THE UNIVERSITY OF
SYDNEY

University of Sydney Submission

Economic Impact Statement, Redfern Station Upgrade - New Southern Concourse

(Application No. SSI-10041)

Figure 18 New Southern Concourse Plan

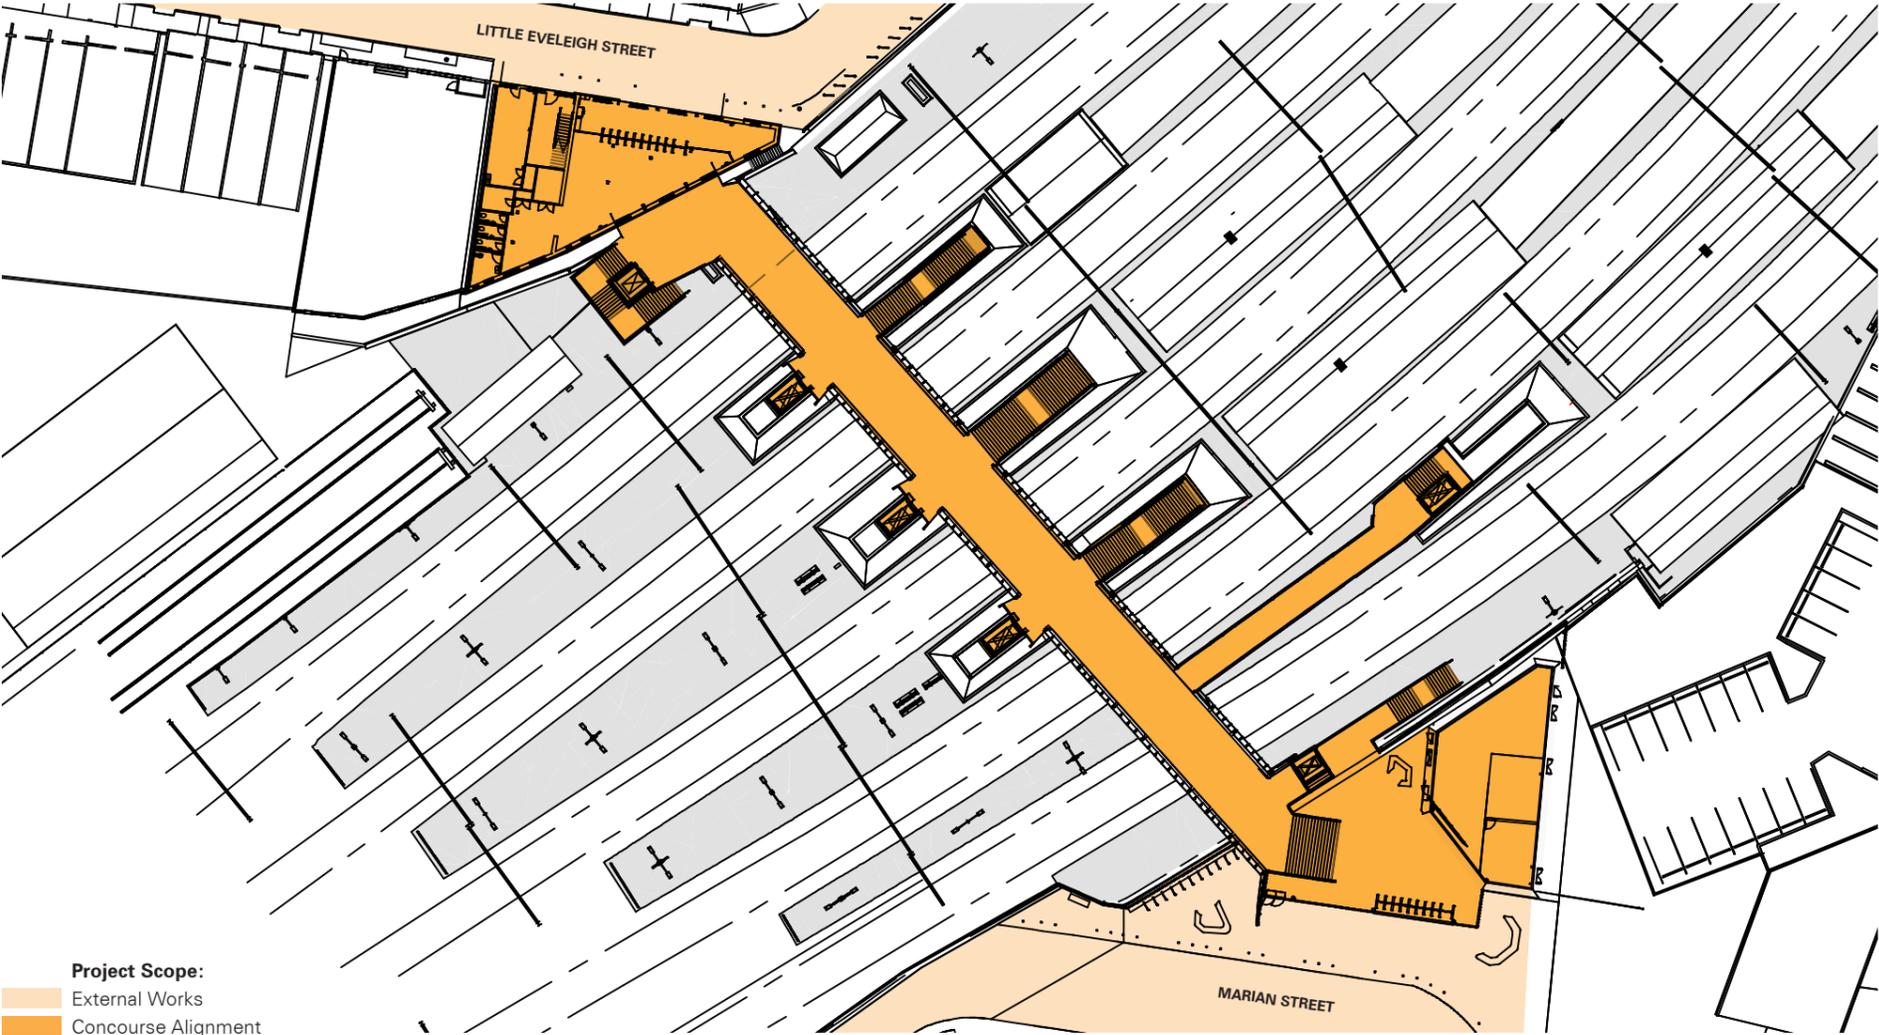
<p>Bridge as a connection between precincts, neighbourhoods</p>	<ul style="list-style-type: none"> - The bridge, as currently designed, is to be gated at each end, meaning the people crossing from one precinct to the other and not using the station will have to go through gates and a ticketing process. The bridge gates will be closed when the station is closed (anticipated to be between 1.45 and 3.45 am. We seek open access to the bridge for pedestrians, as a key facilitator of connection and collaboration between the University, Cicada and South Eveleigh and the future Waterloo Metro station.
<p>Relocation of shuttle bus pickup/setdown area to Lawson St</p>	<ul style="list-style-type: none"> - No design detail provided at this stage. - For future discussion with the University's operations team.

Figure 29 Little Eveleigh Street Concourse - Plan

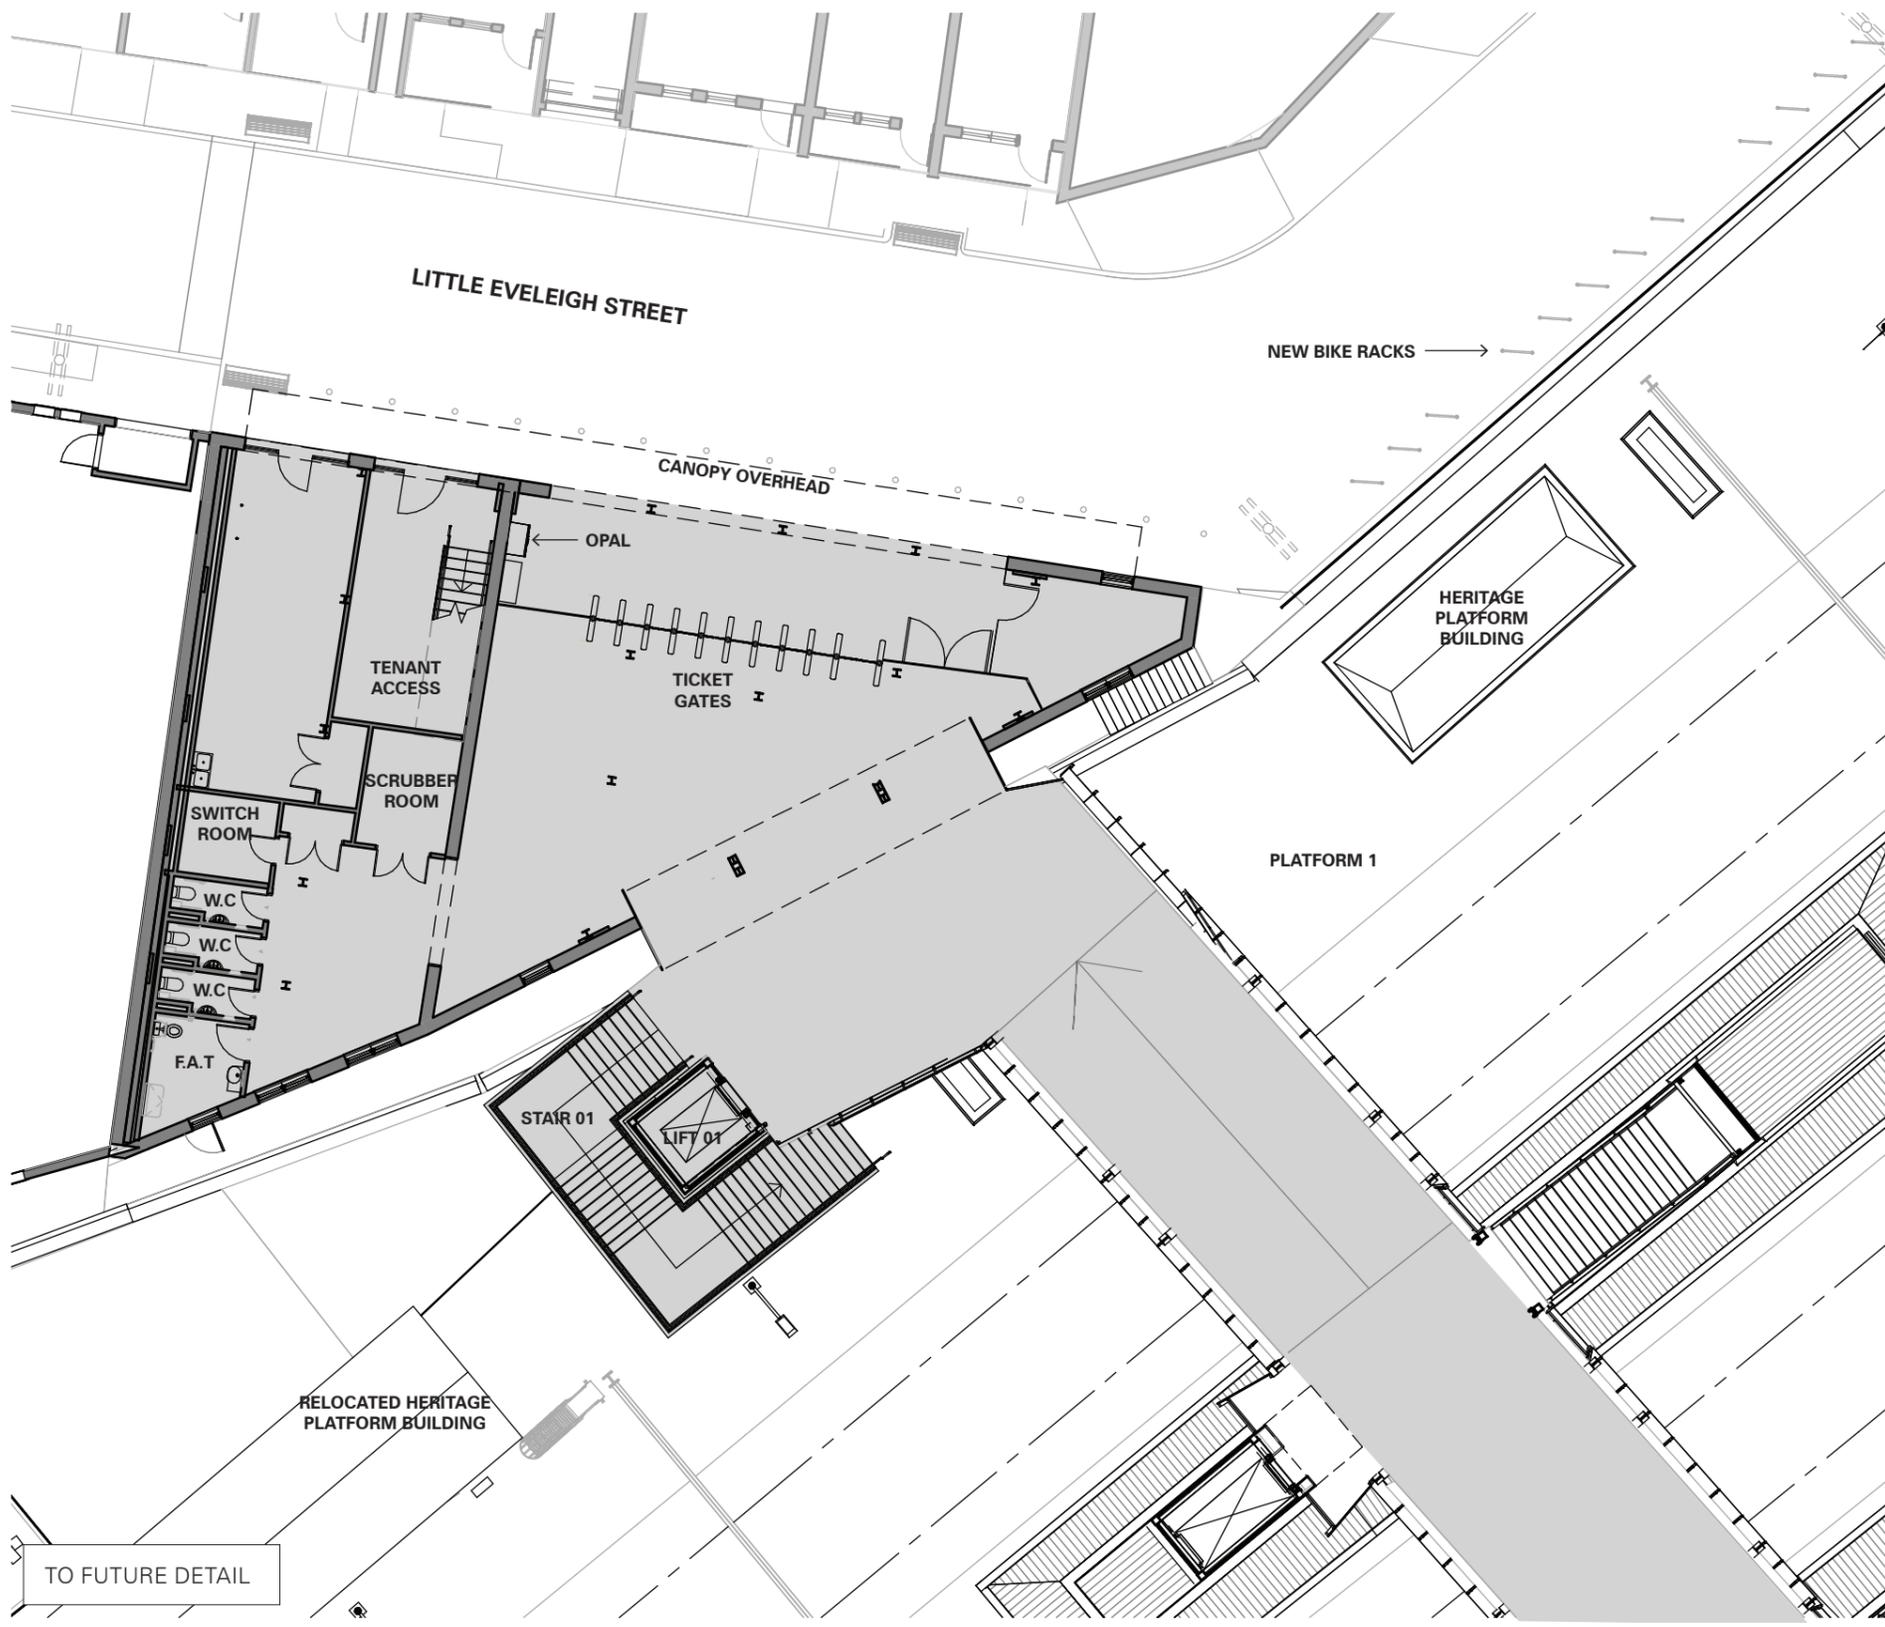
"Little Eveleigh St does not have the capacity to provide safe access for increased numbers of pedestrians and other users in its current configuration. We note the intention to undertake further investigations into converting Little Eveleigh St into a shared way. However, given the complexity of Little Eveleigh St with a multiplicity of users, resident parking, 'kiss and ride' drop off area, shuttle bus stop, garage access and high levels of pedestrian activity, support for Option 1 is contingent on the outcome of required traffic and parking studies and certainty on coordinated delivery with construction of the bridge."

Feedback	Current position
<p><u>Little Eveleigh Street</u></p> <p><i>“.... given the complexity of Little Eveleigh St with a multiplicity of users, resident parking, “kiss and ride” drop off area, shuttle bus stop, garage access and high levels of pedestrian activity, support for Option 1 is contingent on the outcome of required traffic and parking studies and certainty on coordinated delivery with construction of the bridge.”</i></p>	<ul style="list-style-type: none"> - No additional information has been provided on traffic and parking studies, pedestrian interface and safety to enable evaluation of the capacity of Little Eveleigh St to accommodate the pedestrian, services and residential access requirements as a shared way - Provision of alternative resident parking relocated from Little Eveleigh St to TfNSW land adjacent to the Chief Mechanical Engineer's Building (possible future relocation to accommodate North Eveleigh redevelopment plans.) - TfNSW has made a commitment to a co-design process with residents of Little Eveleigh St (two remote sessions and a face-to-face session, if possible, including an offer for the University to participate) which will be held following closure of the EIS consultation period on 24 June.

Given that there remains substantial work to be done to confirm that Little Eveleigh Street can accommodate the shared way functions proposed, and that the bridge is a gated bridge, we cannot support the proposed Southern Concourse bridge in its current form and are therefore lodging this response as an objection.
